PLAN EXAMINATION CONDITIONAL APPROVAL

PROJECT/SITE DESCRIPTION:
Maine Medical – Visitor’s Garage Extension

PROJECT ADDRESS:
22 Bramhall St – Portland, Maine

Review Type:	All Trades
Plans Date:	3/30/18
# of Sheets:	96
Project Area (sq. ft.):	82,201

1 SOUTH ELEVATION

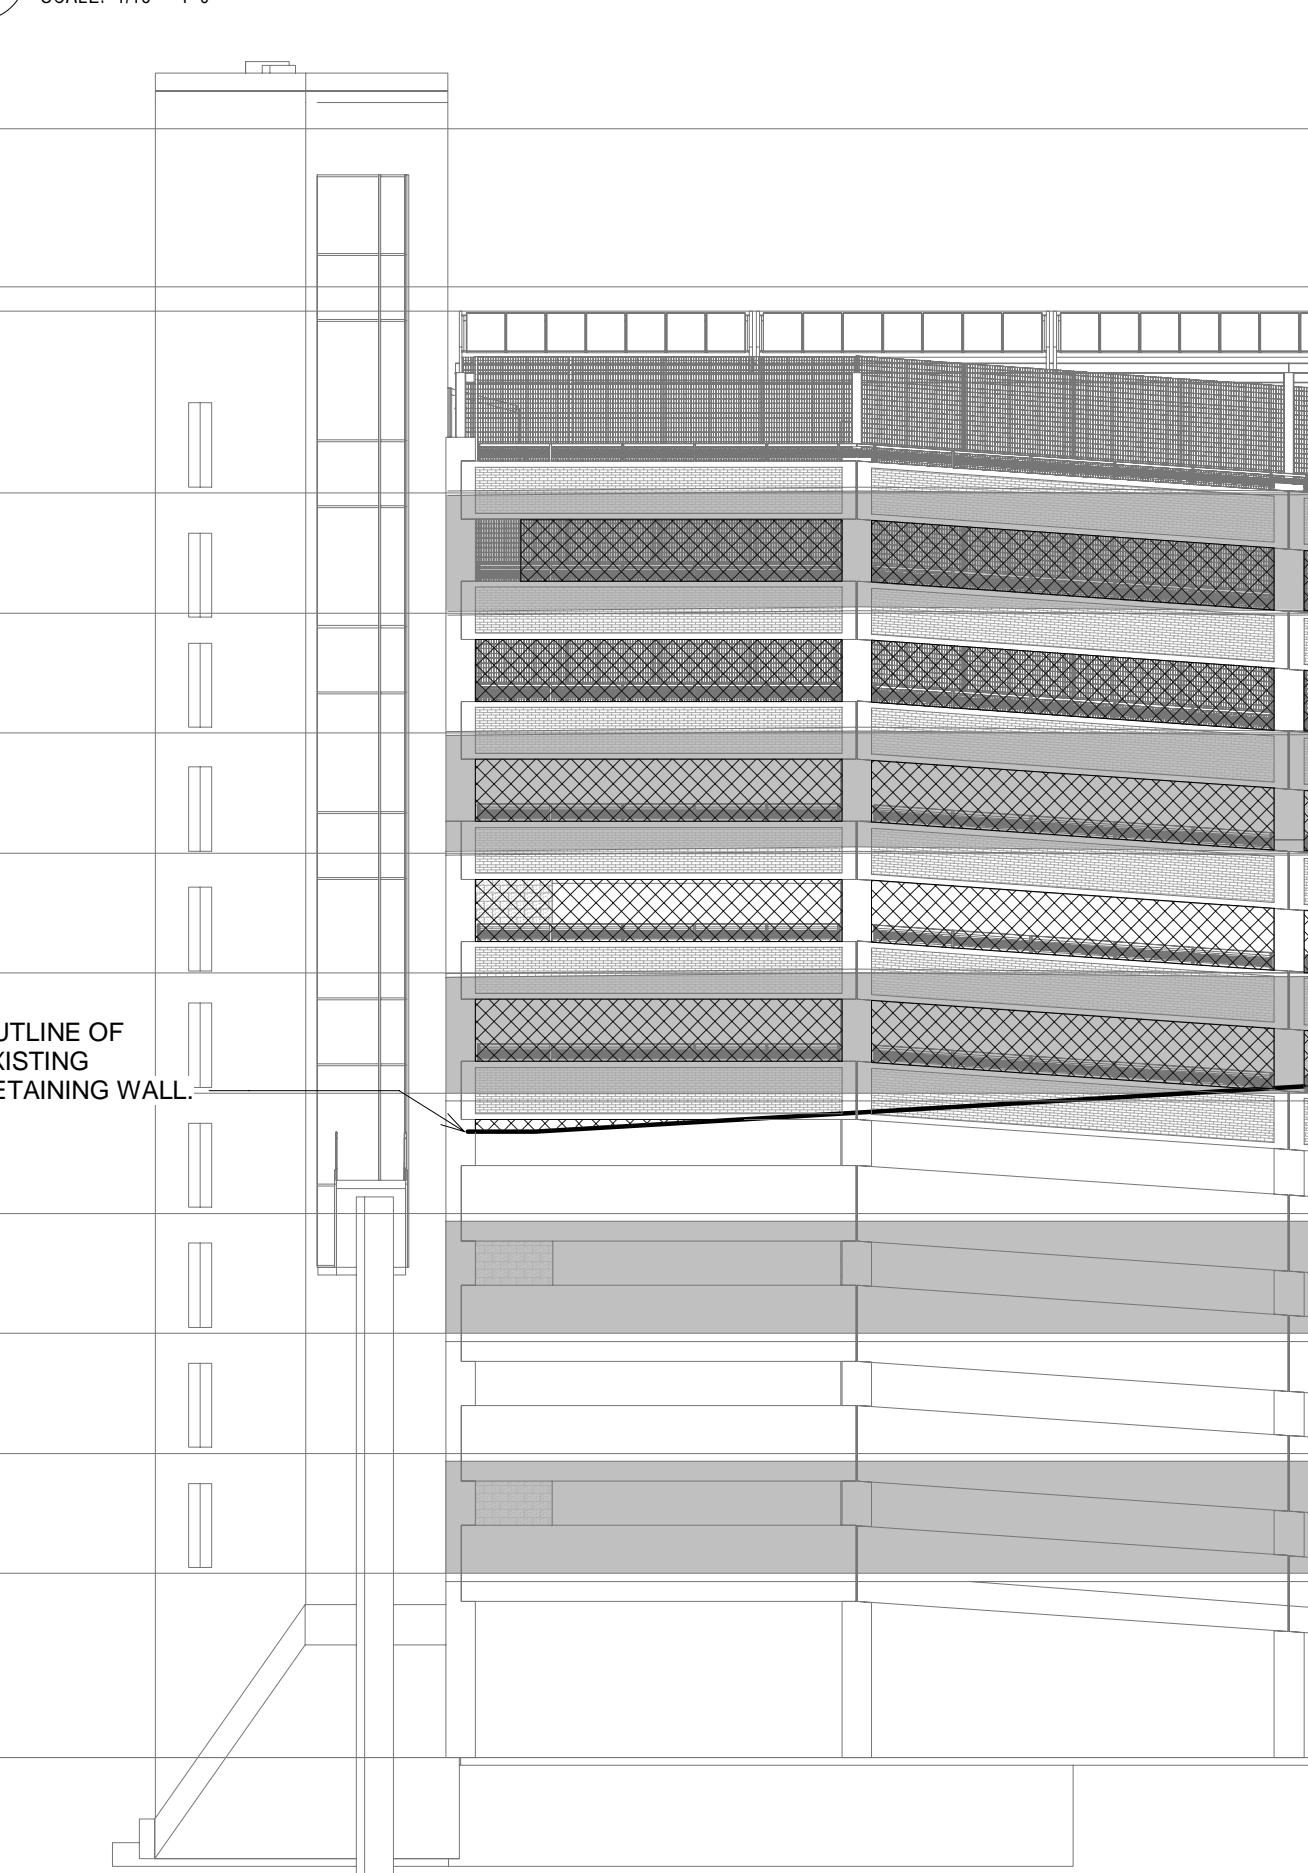
Plan Review Comments are based upon updated G02-01 Code Compliance Elevations sheets provided during review 3/27/18 demonstrating ventilation requirements meeting code requirements to allow for structure to be considered as an "Open Parking Structure".
